A66 Northern Trans-Pennine Project

7.34 Applicant's Responses to the Examining Authority's Further Written Questions

Deadline 6

04 April 2023

Drawing Title: Classification of Roads Plan Regulation 5(2)(o)
Sheet 1 of 1

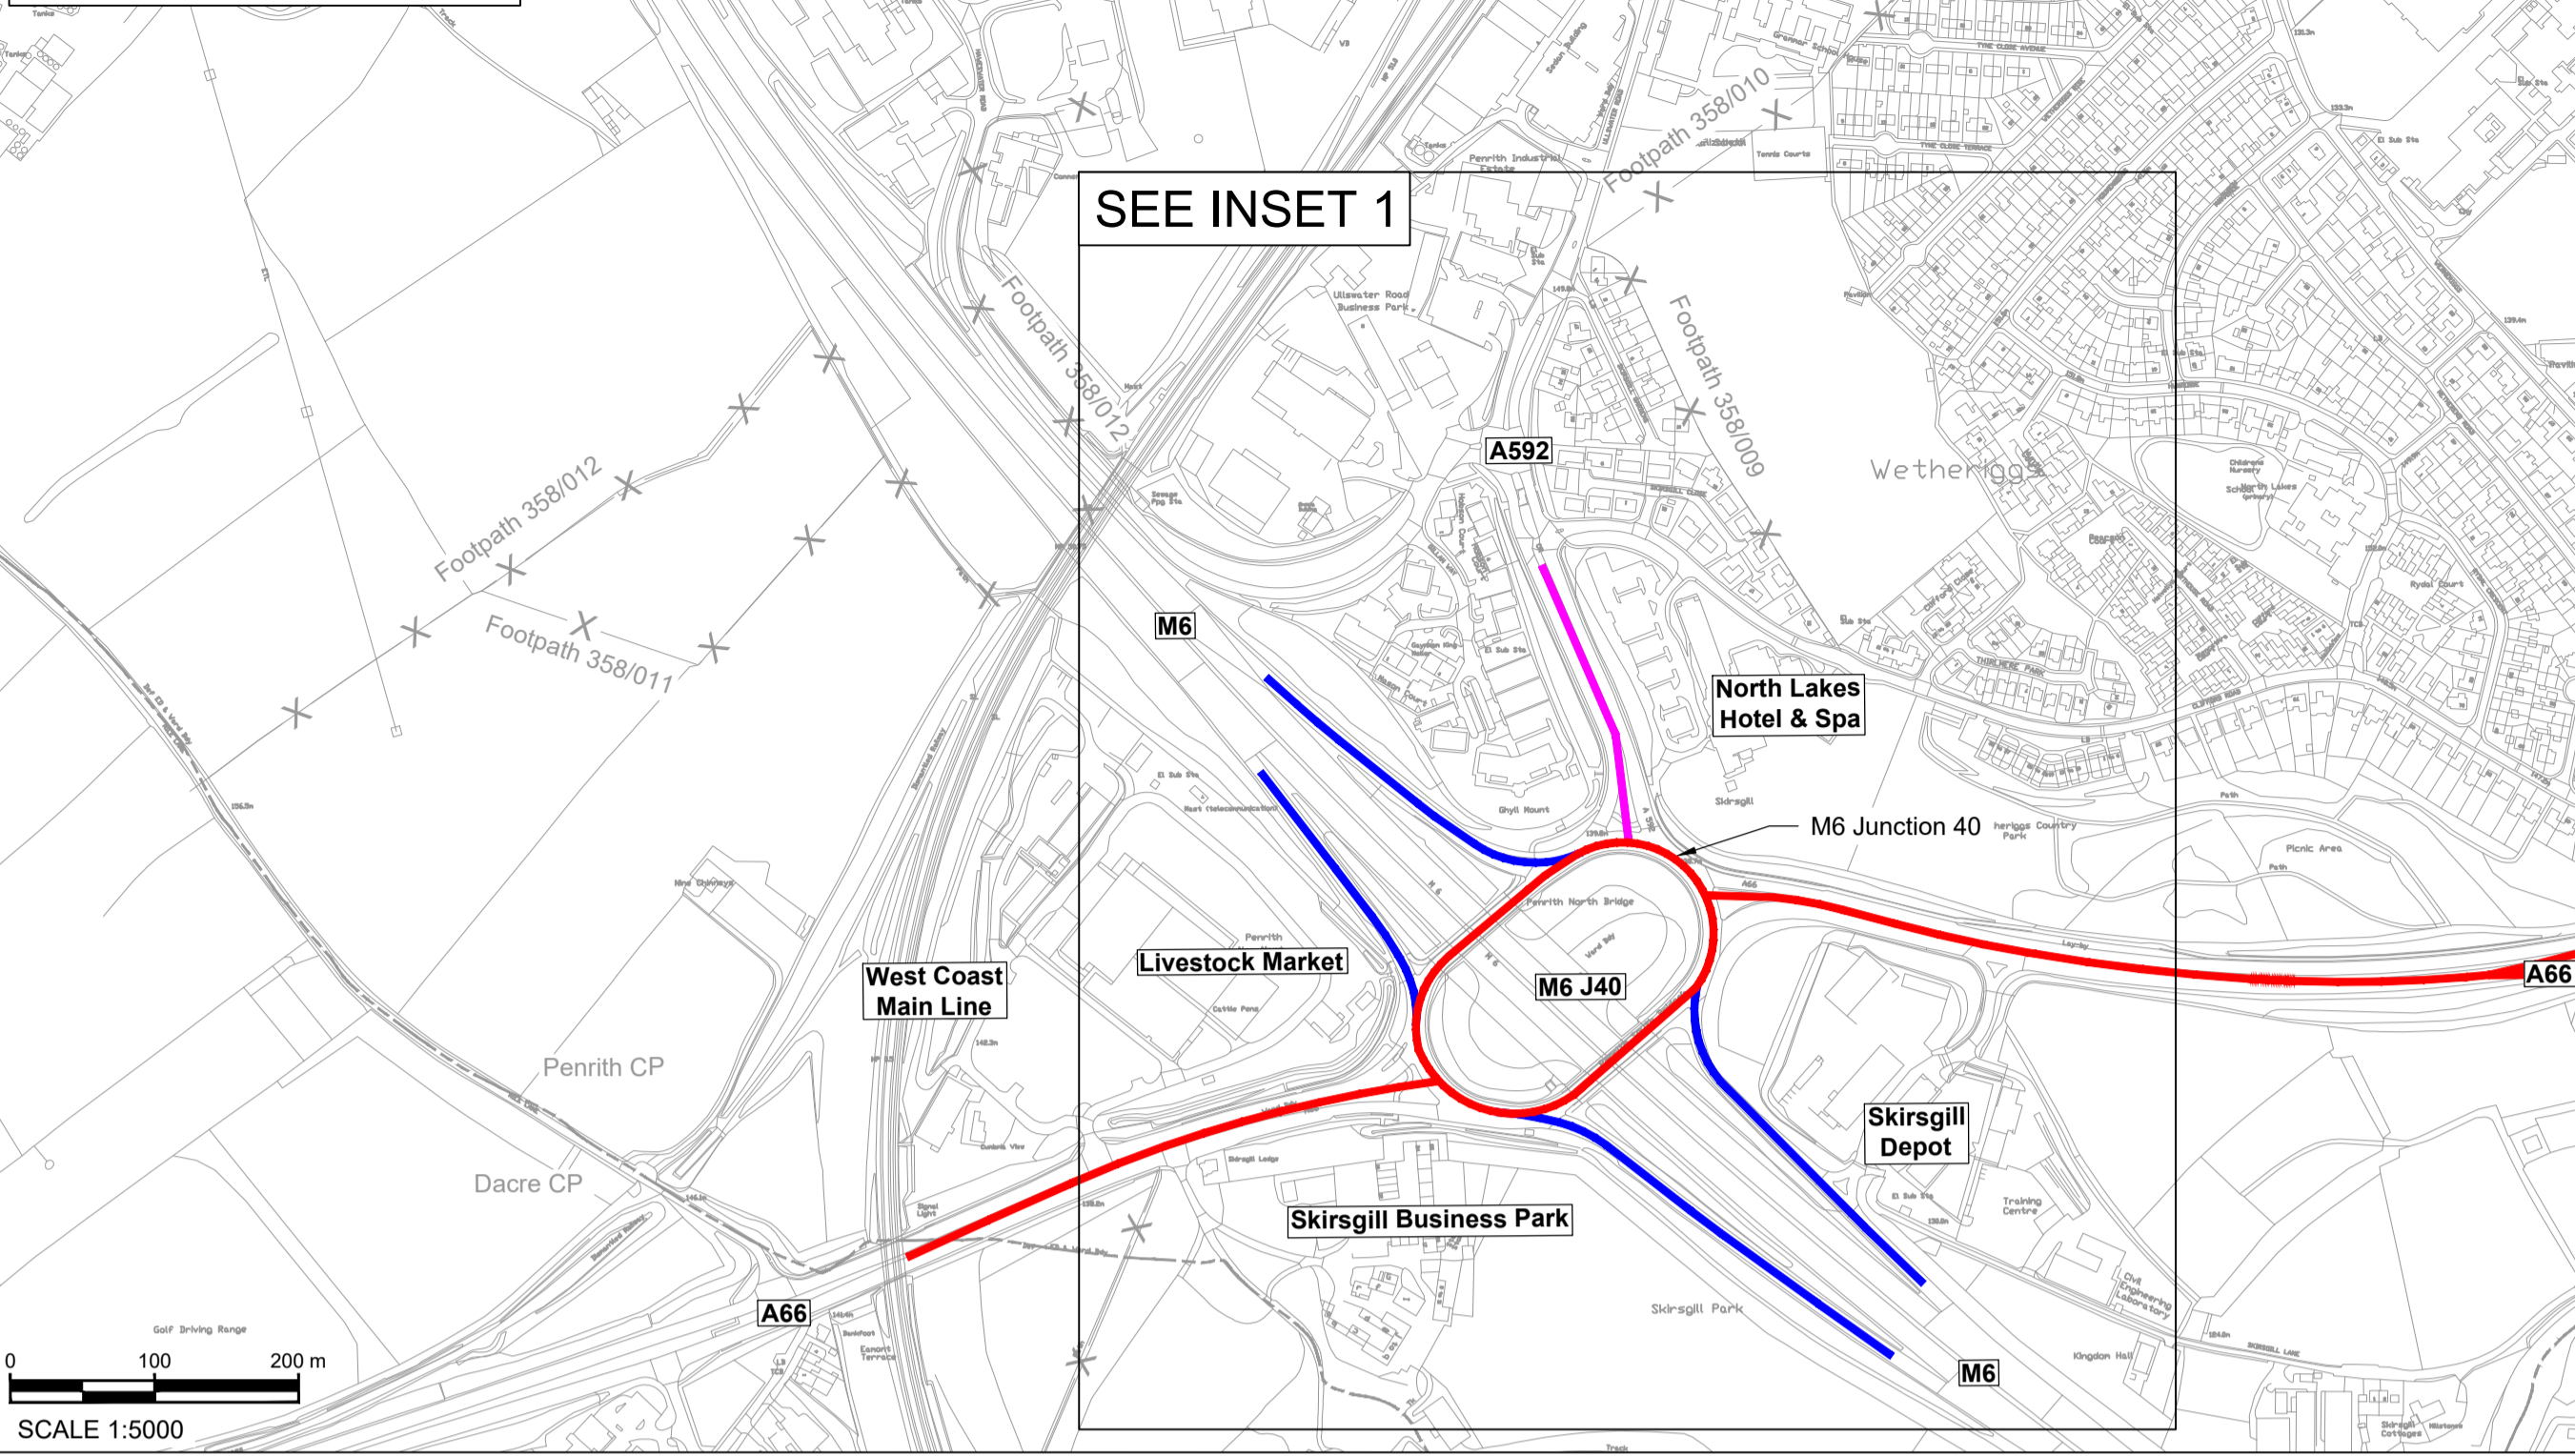
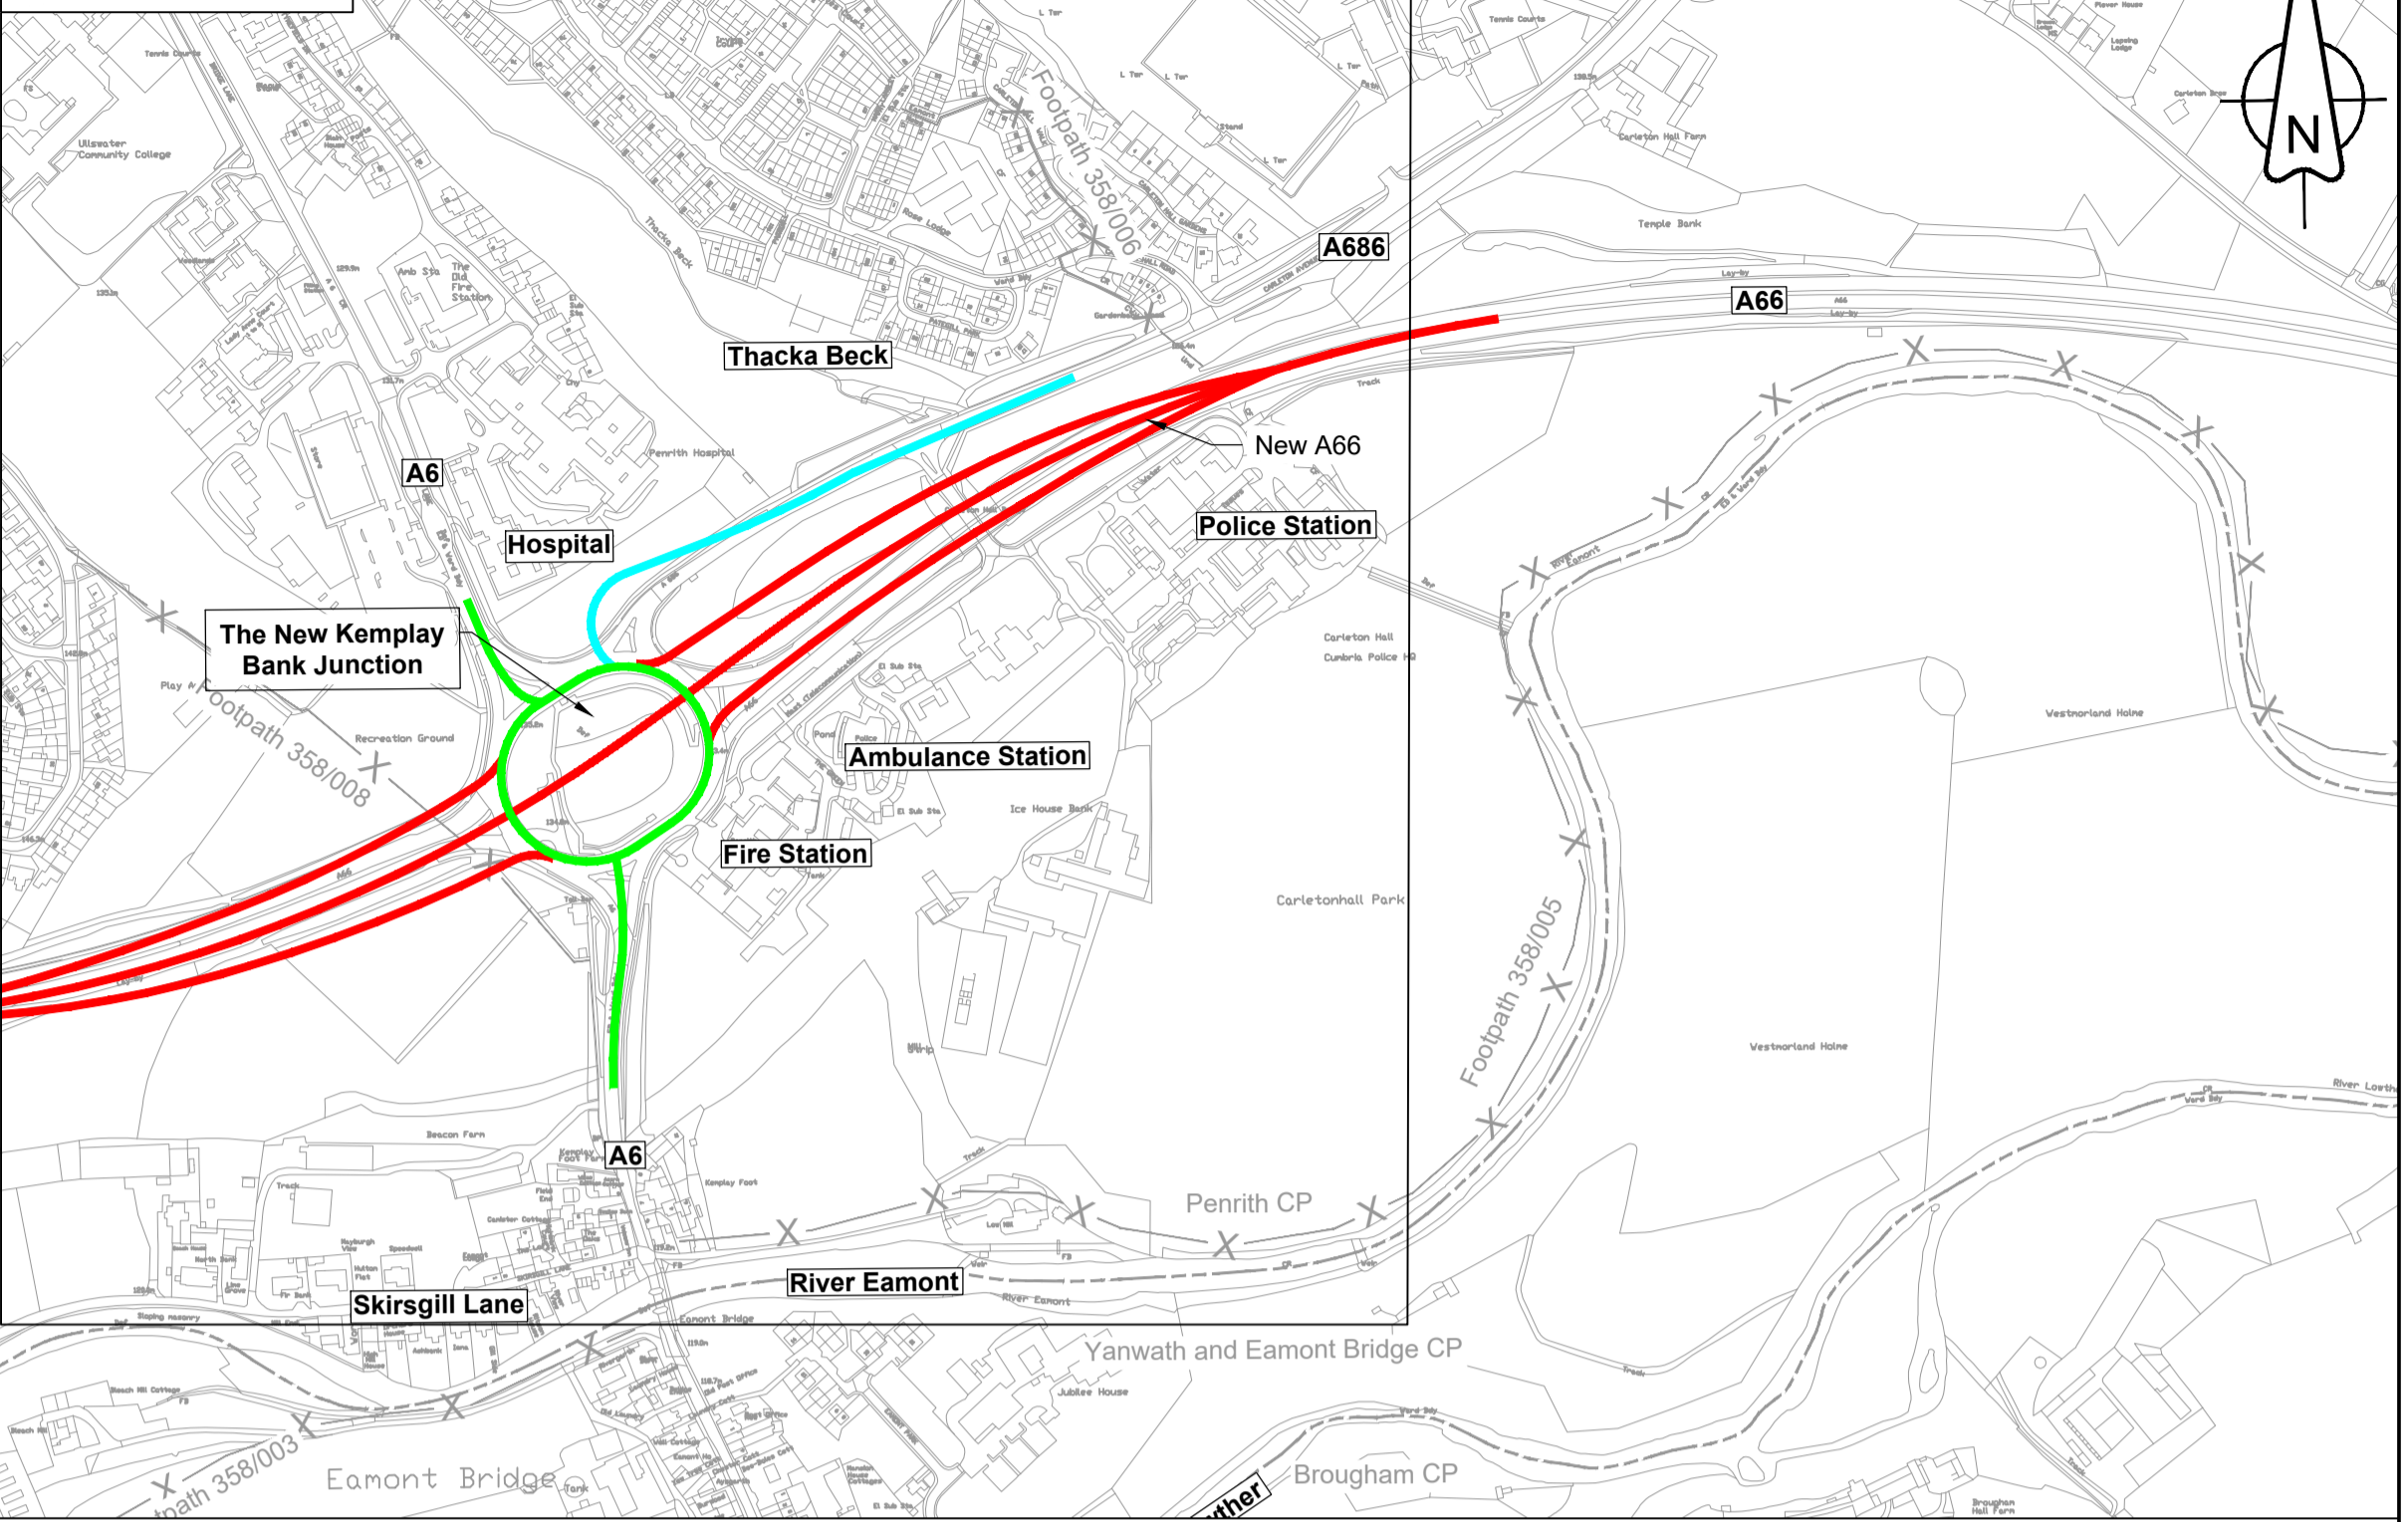
Ref Number	Subject	Response by	Question	Applicant's Response																																				
			that the classification number to the de-trunked section of the A66 should be unique and is under discussion with Cumbria CC. The latest draft DCO [REP5-012] still refers to the B1066, which is not a unique classification number. Explain why this has not been amended.																																					
GENERAL MATTERS																																								
GM 2.1	SoCGs	The Applicant All Relevant Interested Parties	Table 4.1 of the Statement of Commonality for SoCGs [REP5-003] sets out the position of each SoCG between the Applicant and the relevant Interested Party. The Applicant is requested to update the table setting when it expects the final and signed SoCGs will be submitted into the Examination. Interested Parties who disagree with their respective draft SoCGs are requested to inform the ExA at Deadline 6, Tuesday 04 April 2023.	<p>A revised version of Table 4.1 is provided below. This has been updated in the Statement of Commonality that will be submitted at Deadline 8.</p>
